# SITE DEVELOPMENT PLAN FOR 19955 WIGWAM ROAD

A PORTION OF LAND IN THE NORTHWEST QUARTER OF SECTION 26, TOWNSHIP 17 SOUTH,  
RANGE 65 WEST OF THE 6TH PRINCIPAL MERIDIAN,  
EL PASO COUNTY, COLORADO

SITE DEVELOPMENT PLAN  
COVER SHEET

DP-1 MVE PROJECT 61180  
MVE DRAWING DEV-CS

SITE DEVELOPMENT PLAN

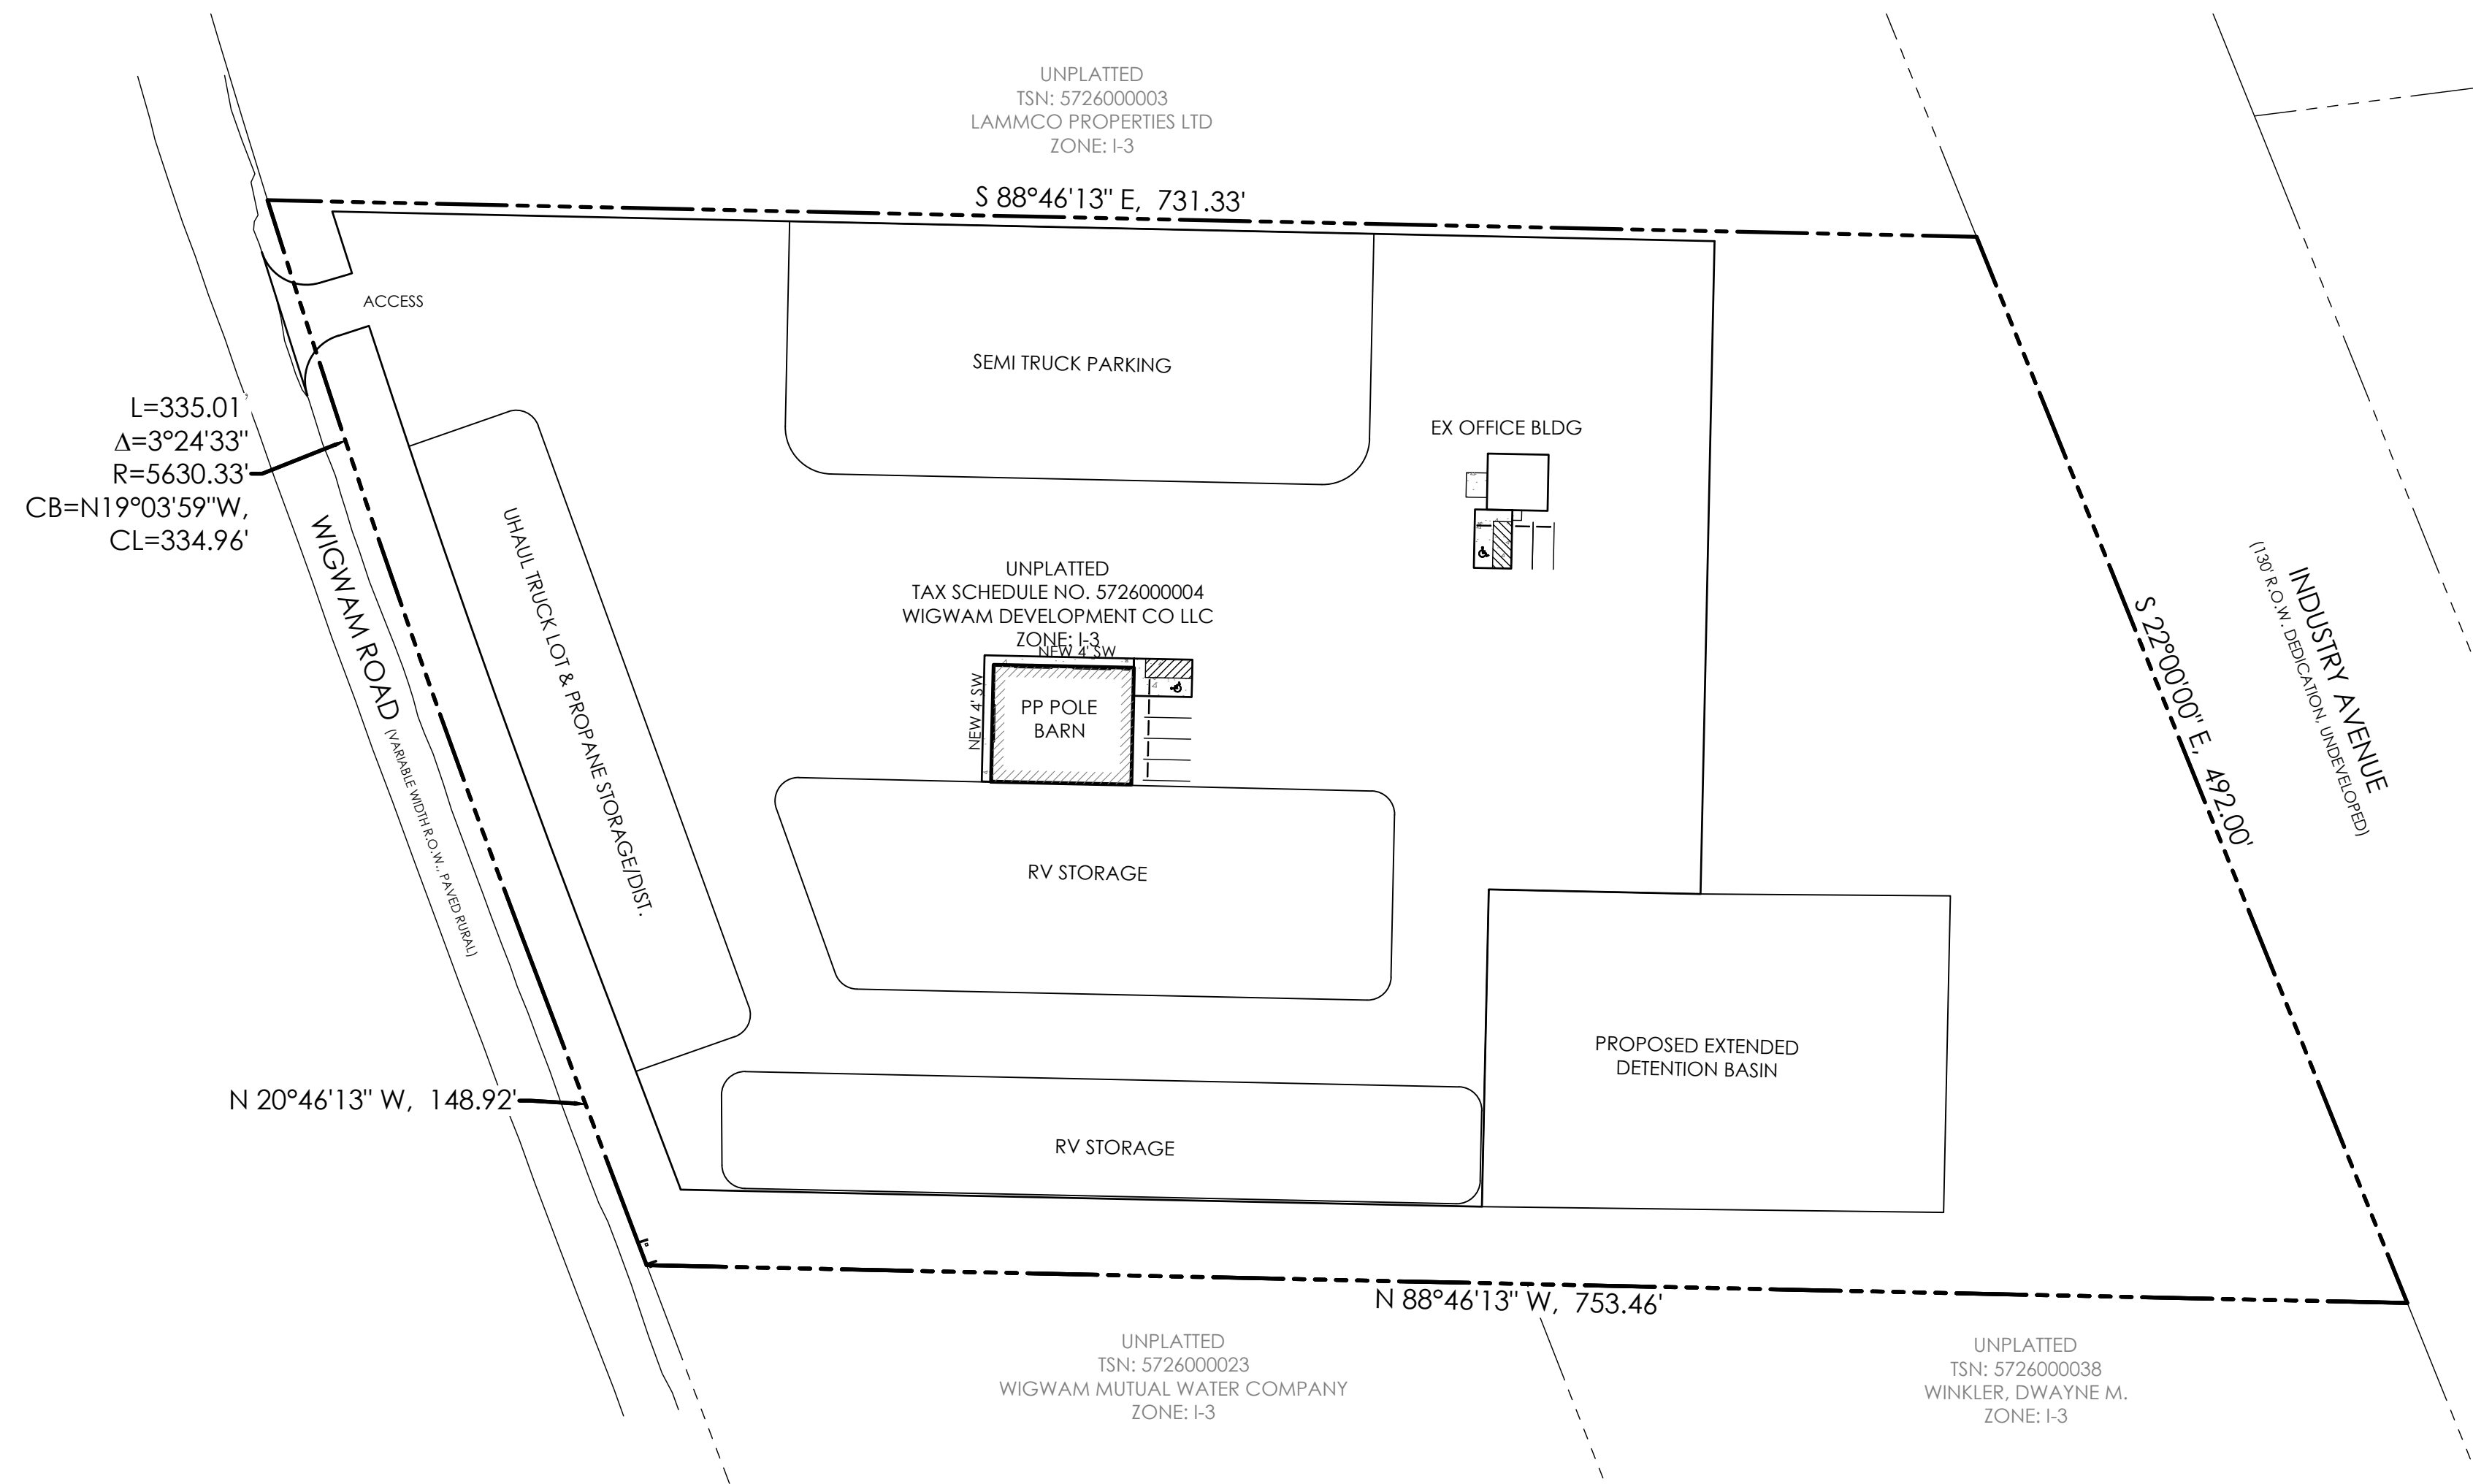
Please indicate locations of the following:  
- garbage receptacles and screening mechanisms  
- existing and proposed utility lines  
- existing and proposed easements

**Comments from MVEA:** MVEA has existing facilities near and within this parcel of land. If there is any damage, removal or relocation of facilities it will be at the expense of the applicant. MVEA will work with the developer on the design of the electric service and to acquire any needed utility easements. MVEA also requests the platting of MVEA's existing facilities with easements on the plat.

**Comments from Hanover Fire Protection District:**  
1. Knox box attached to the Pole barn and office.  
2. Propane fill station No Smoking signs within 50ft and fire extinguishers.  
3. Fire mitigation plan for interior and exterior of the lot needs to be addressed.  
4. Water cistern minimal requirements and locations will need to be calculated based on number of UHaul rental, RV storage spaces, buildings, size of Propane tanks and semi-truck parking.

TYPICAL SWALE "NORTH"
NHS

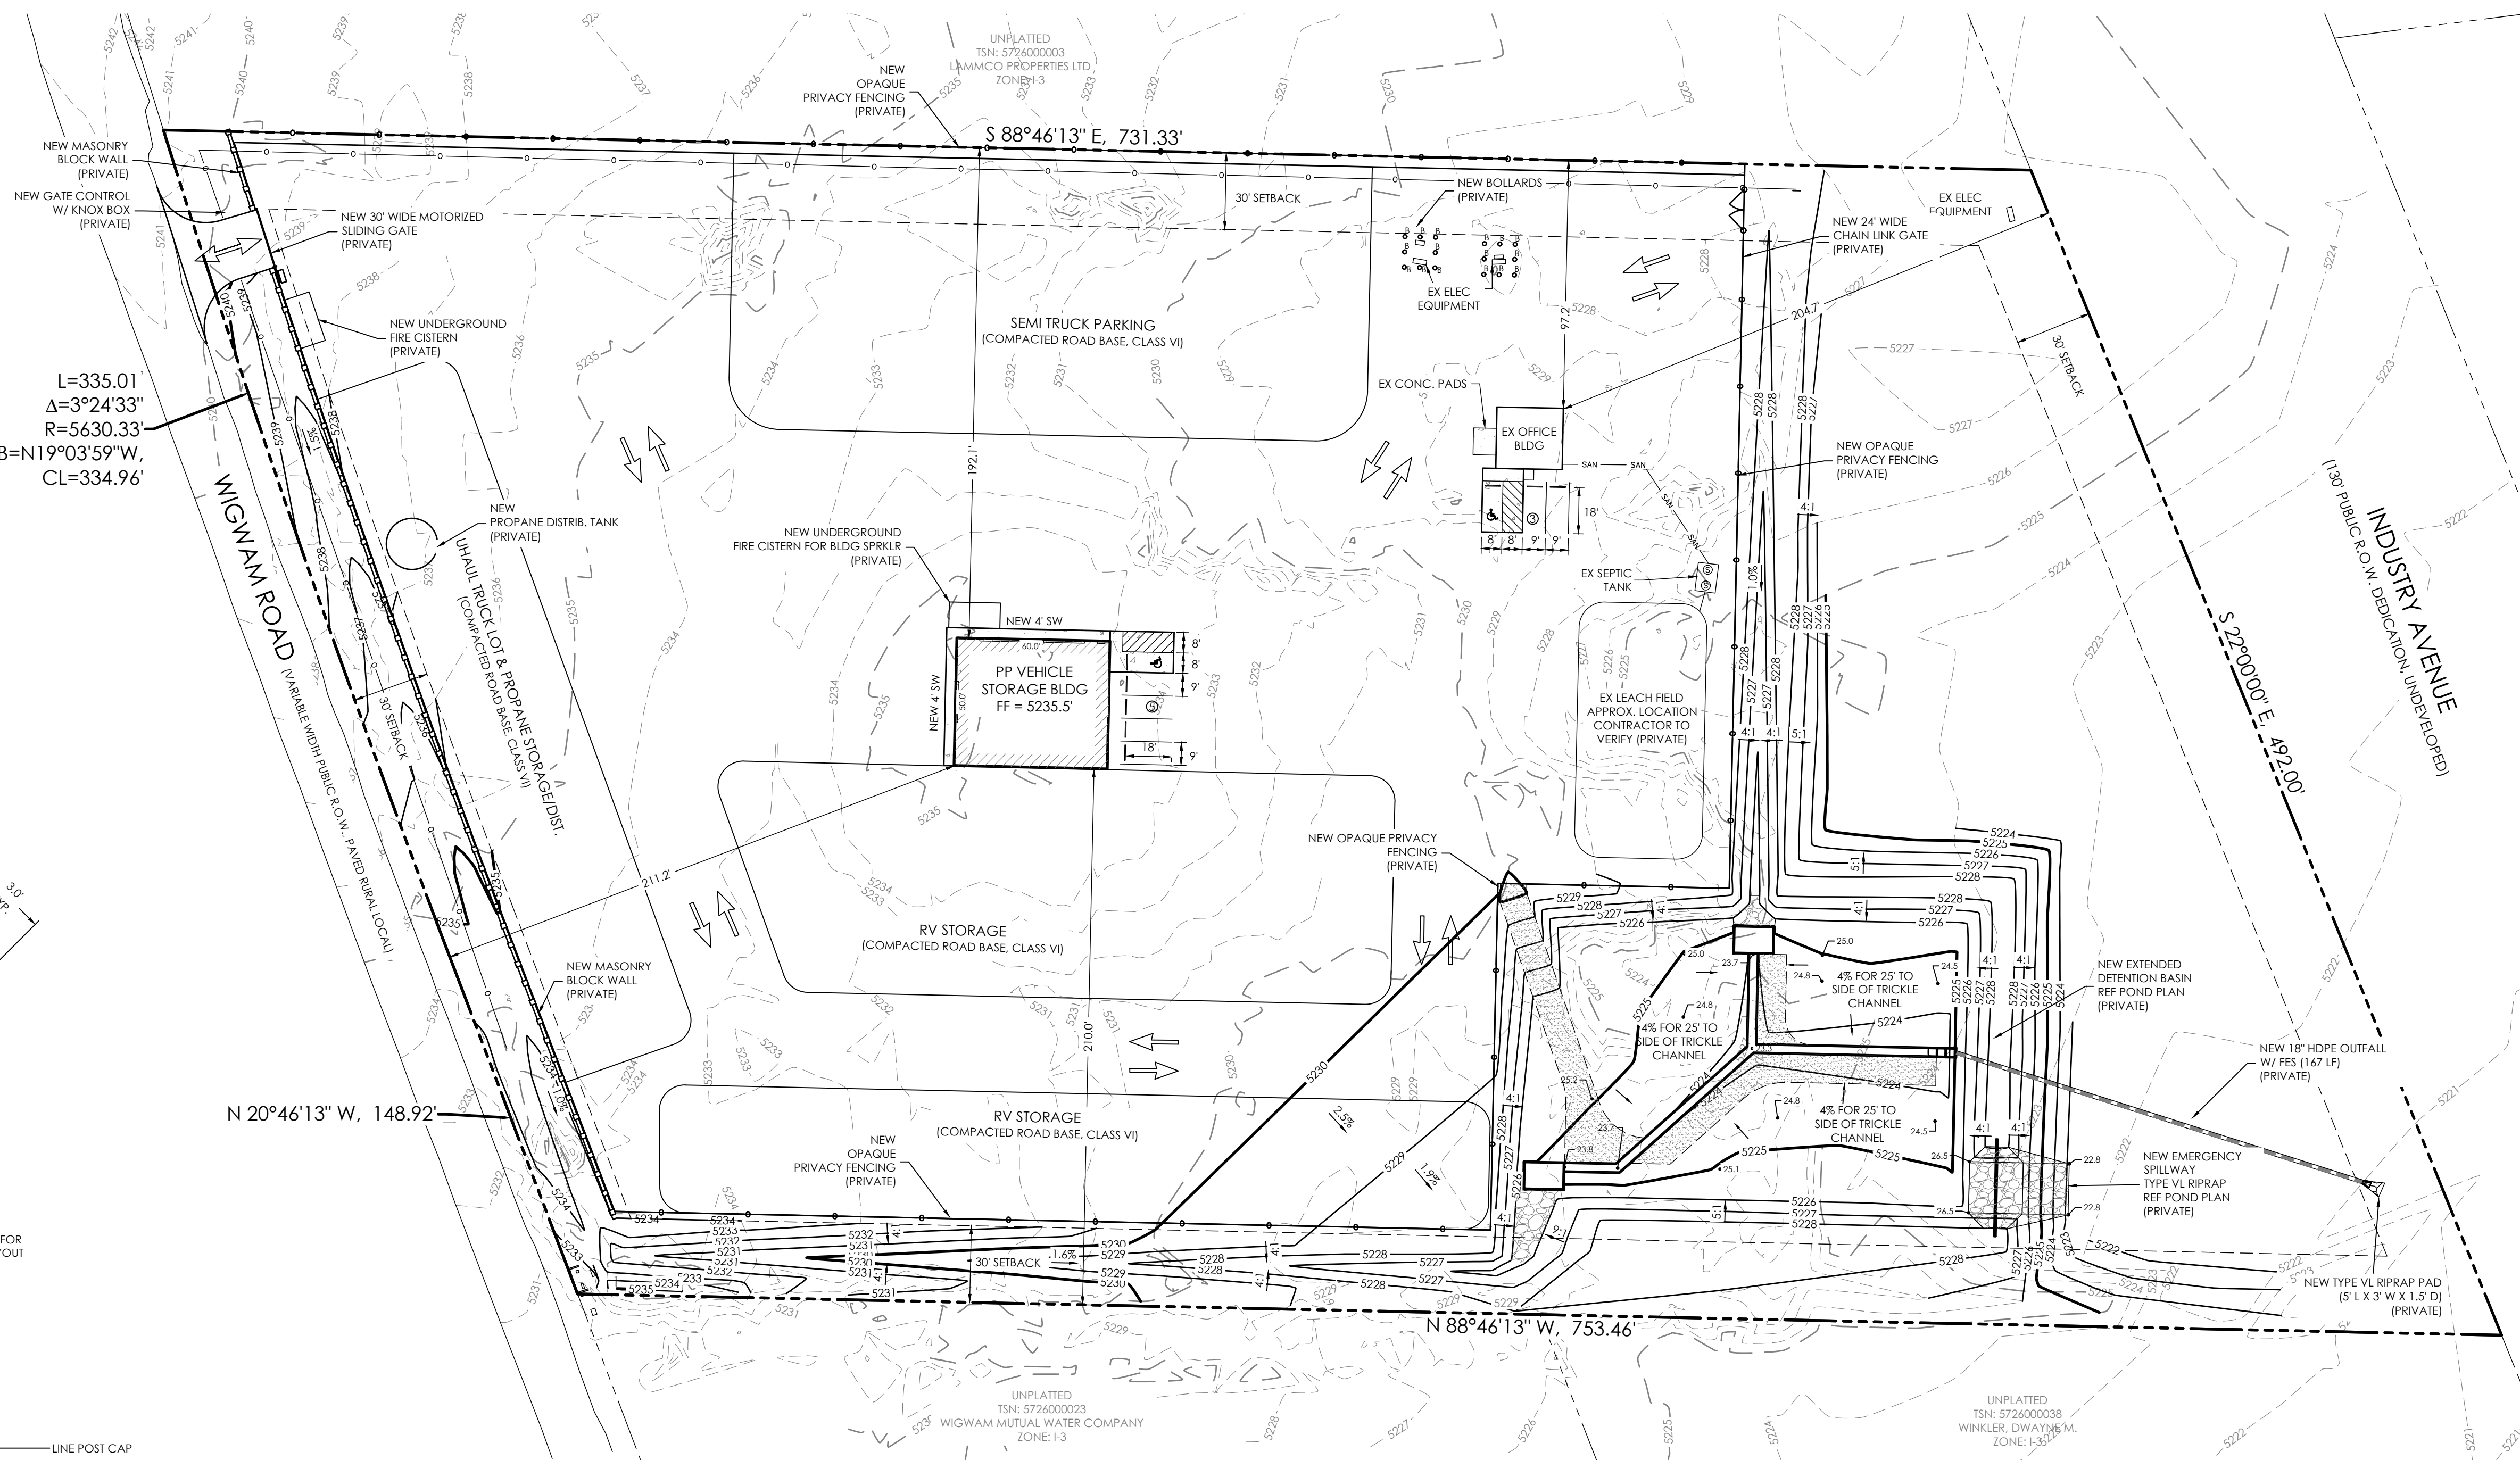
Provide detail for the "south" swale as well or clarify this applies to both.
